re: **Response to Engineering Comments**
 Wateridge Village Residential Development - Block 22
 1400 Hemlock Road - Ottawa

date: September 10, 2020

file: PG5345-MEMO.07

Comments - Geotechnical Investigation

SITE SERVICING PLAN			
DRAWN BY:	A.W.T.	CHECKED BY:	S.L.M.
DESIGNED BY:	S.L.M.	CHECKED BY:	A.D.F.
SCALE:	1:250	PROJECT No.	17-948
			SHEET No.
			04

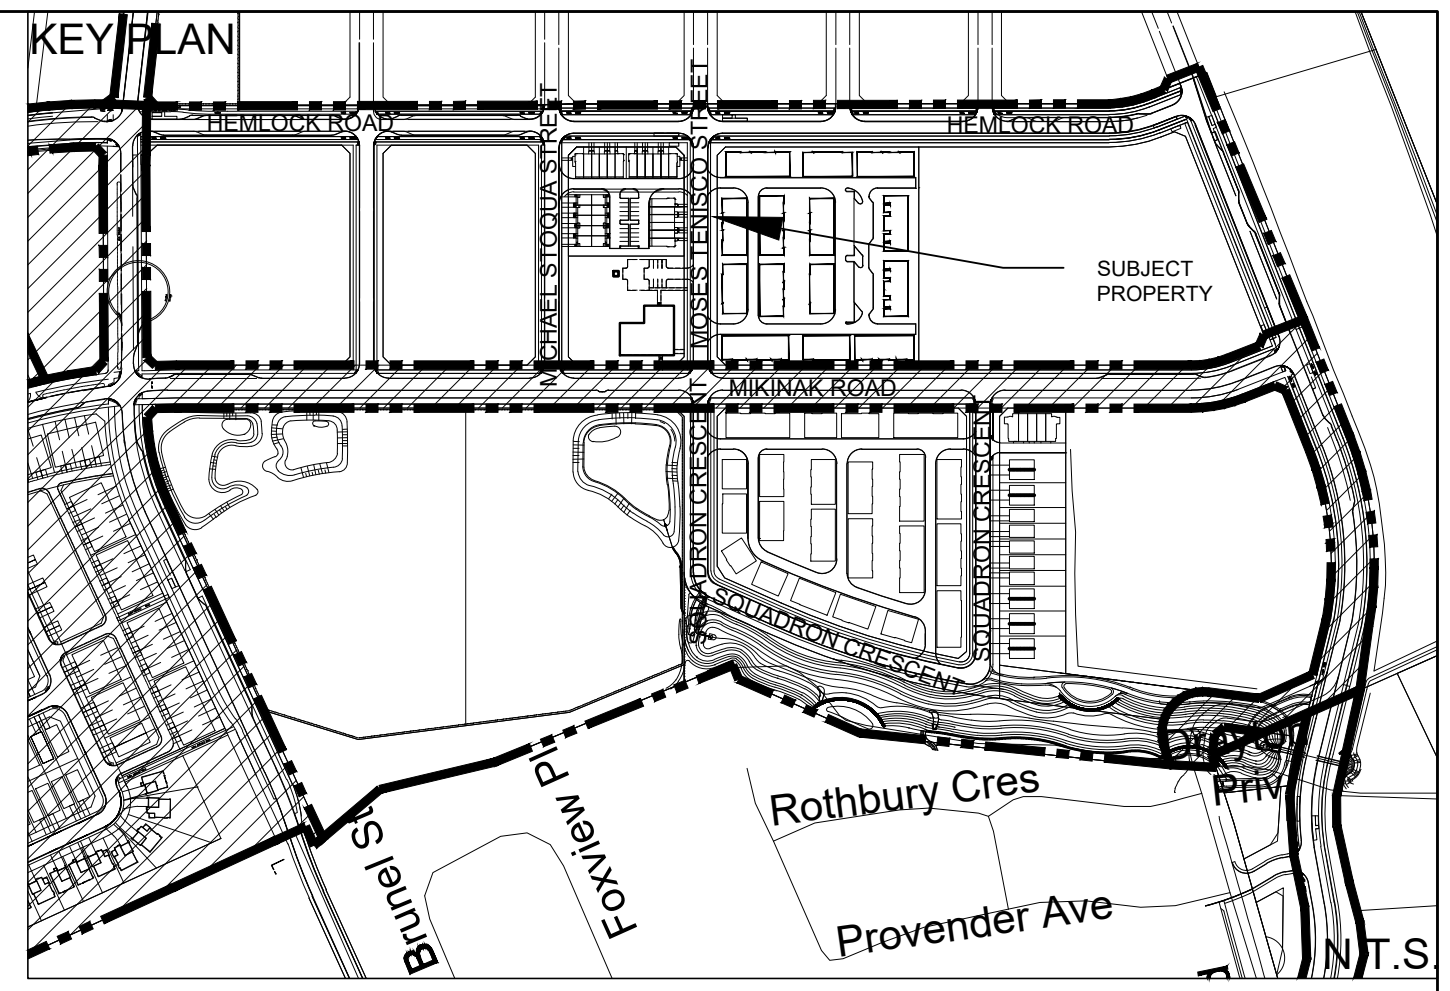
Item 41: *Please document the elevation difference between the bottom of the storage media of the oversized perforated pipe systems and the seasonally high groundwater elevation for the site. The bottom of the storage media is required to be minimum of 1m below the seasonally high groundwater table per Ministry requirements. Provide a memo that confirms this requirement can and is being achieved based on a review of the proposed LID practices for this site.*

Response: Based on our review of the current servicing plans (Drawing No. 04 - Site Servicing Plan, Project No. 17-948, Revision 11 dated June 23, 2020, prepared by DSEL), the lowest elevation of the bottom of the proposed storage media is approximately 87.5 m. Based on our findings in the geotechnical report and existing borehole coverage, the current long-term seasonally high groundwater table is estimated between an elevation of 86.5 to 85.5 m. However, it should be noted that a 0.5 m of post-development groundwater lowering will occur within the vicinity of the subject site. Therefore the post-development long-term groundwater table is estimated at an elevation of 86.0 to 85.0 m.

Based on the available information, the elevation of the base of the storage media at 87.5 m conforms to having 1 m of separation from the seasonally high groundwater table. Therefore, the design of the infiltration system is acceptable from a geotechnical perspective.
